Responses to Any Further Information at Deadline 7

Application by Luton Rising to extend London
Luton Airport

Author: Luton Borough Council (the local planning authority [LPA])

Date: 23 January 2024

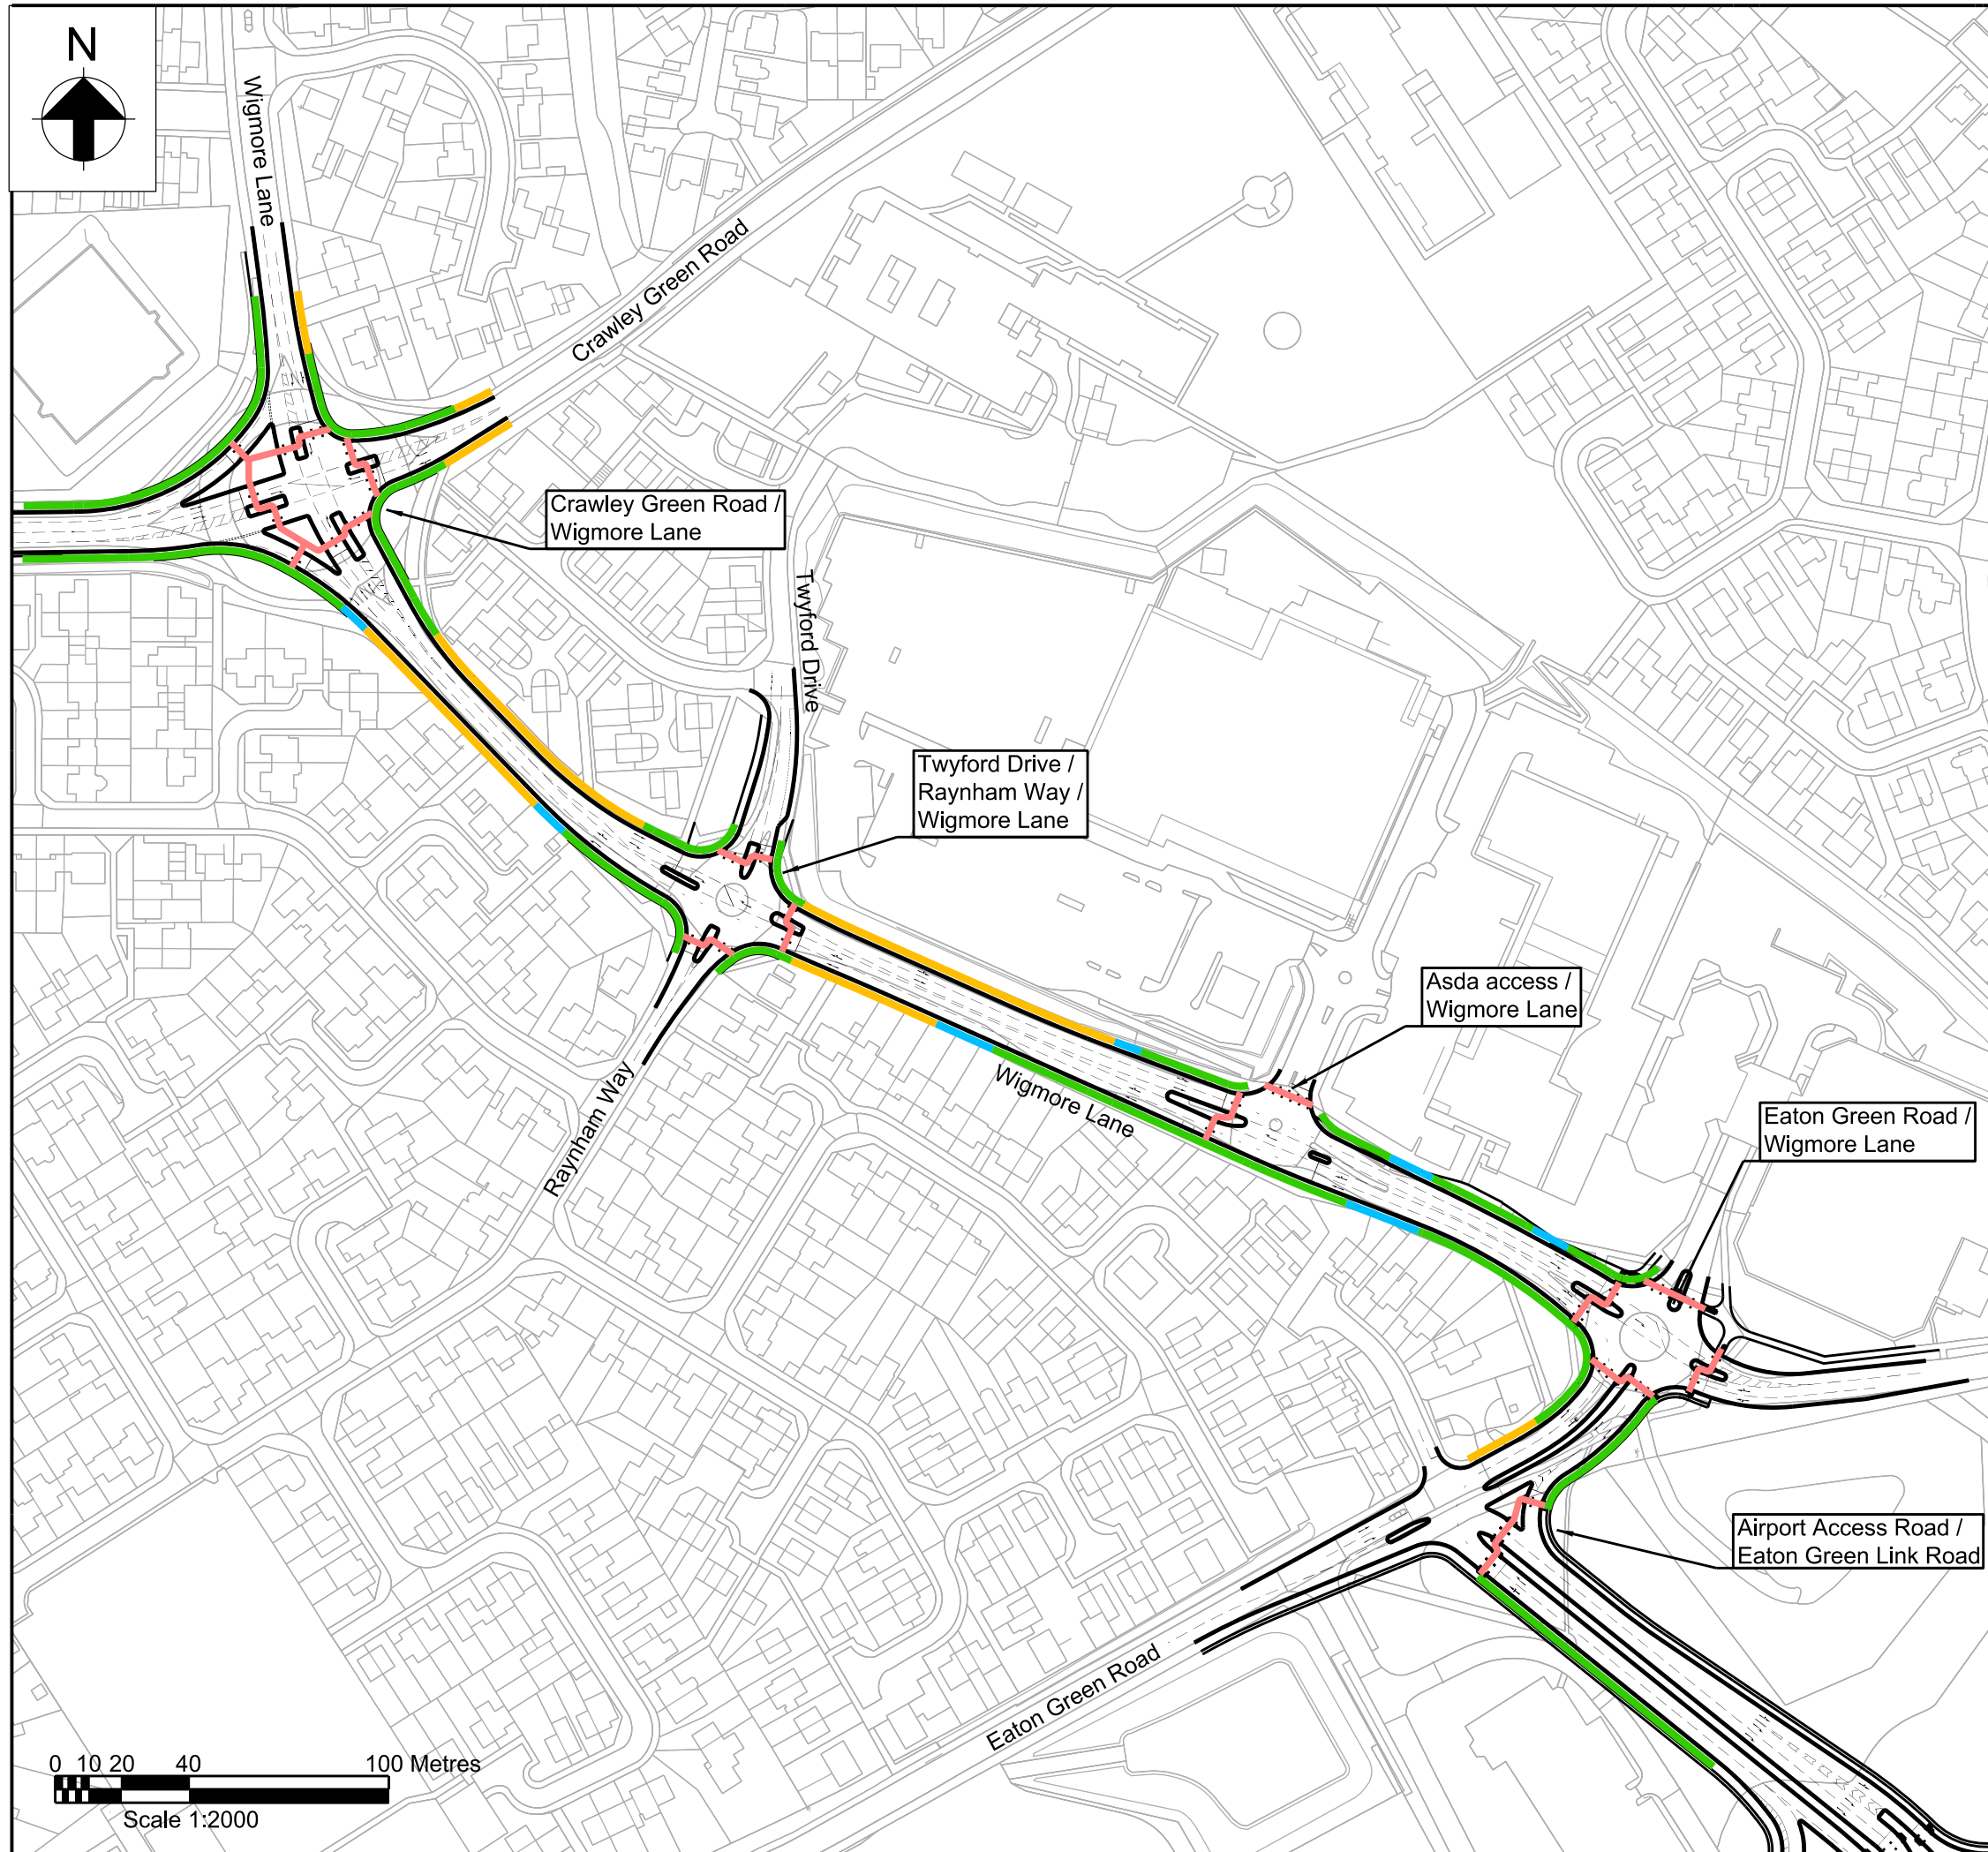
Reference	Subject	Comment
Drawing LLADCO-3C- ARP-SFA- HWM-DR- HY1511	Wigmore Lane	In accordance with the council's Post-Hearing Submission Responses to ISH7 Action Points [REP6-105], LBC remains satisfied that scheme design along Wigmore Lane is entirely consistent with the ambitions of the council's Local Cycling and Walking Infrastructure Plan. This is as a result of close working between the Applicant and the local highway authority. It also remains the view of LBC that scheme design for Wigmore Lane is in accordance with LTN/120 and corporate plans, providing a net-betterment for non-motorised transport users.
